Consolidated responses to comments from State Design Review Panel (SDRP)

Table 1: Updated response to comments from first SDRP session held on 28 April 2021

Table 2: Response to comments from first SDRP session held on 28 April 2021

DRAWING NAME  
**LANDSCAPE: SITE FINISHES PLAN**

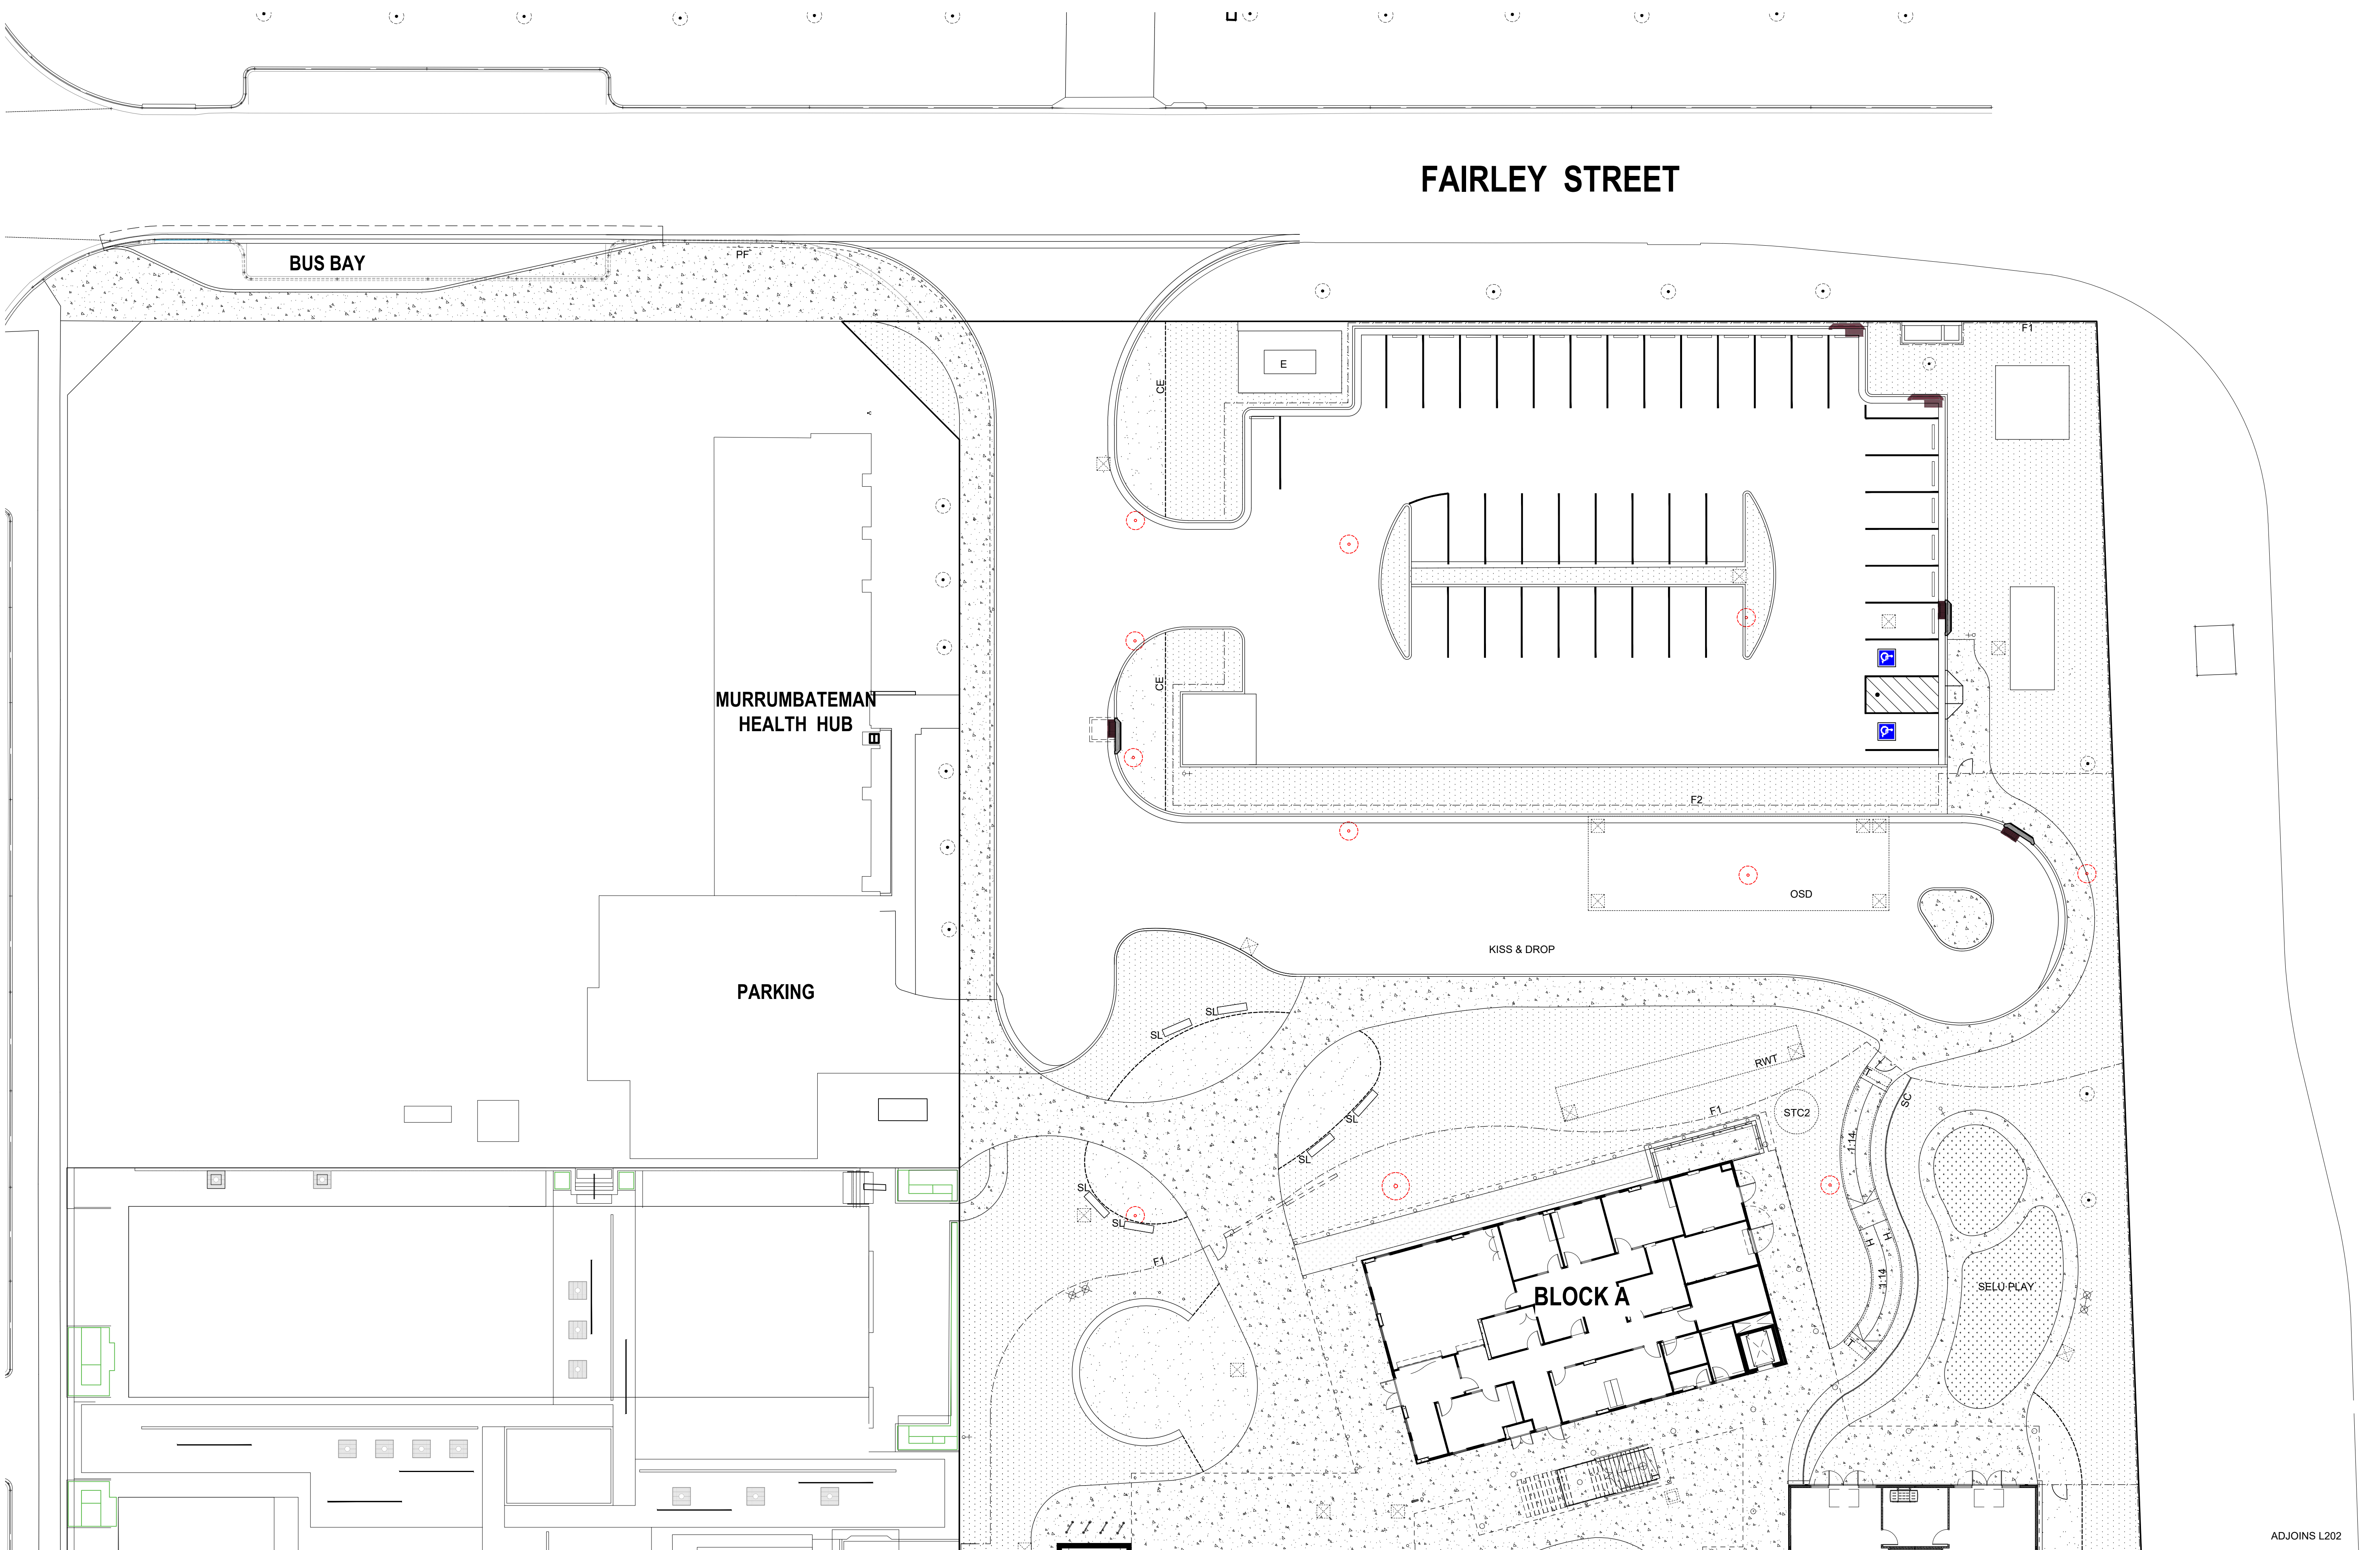
The main entry's address to the public domain needs development as outlined in the following advice from SDRP 1:

'Develop a stronger civic address at the main entry that promotes a sense of arrival. Include traffic calming devices such as textured paving, trees, shared ways, etc. to reduce the dominance of vehicles and ensure the circulation from the street to the school entry is pedestrian friendly.'

- Investigate reconfiguring the vehicle circulation to reduce the amount of roadway required. Integration of the kiss and drop and turning bay with the car park circulation should be explored.
- Traffic calming devices such as paving materials should be utilised to slow down the speed of the cars and promote shared ways where appropriate, particularly around the kiss and drop zone.
- Utilize trees and vegetation at the Fairley Street entry, to improve the street presence, identity of the school and conceal the substation.

Further detail on finishes has been provided in the updated landscape report at Appendix 2 of the RtS. As shown in the finishes plan (MURR-DD-L200), the entry forecourt will include a mixture of mass planting bed, turf and paving, which will promote a sense of arrival.

Additionally, further tree plantings have been added at the main entry adjacent the substation.
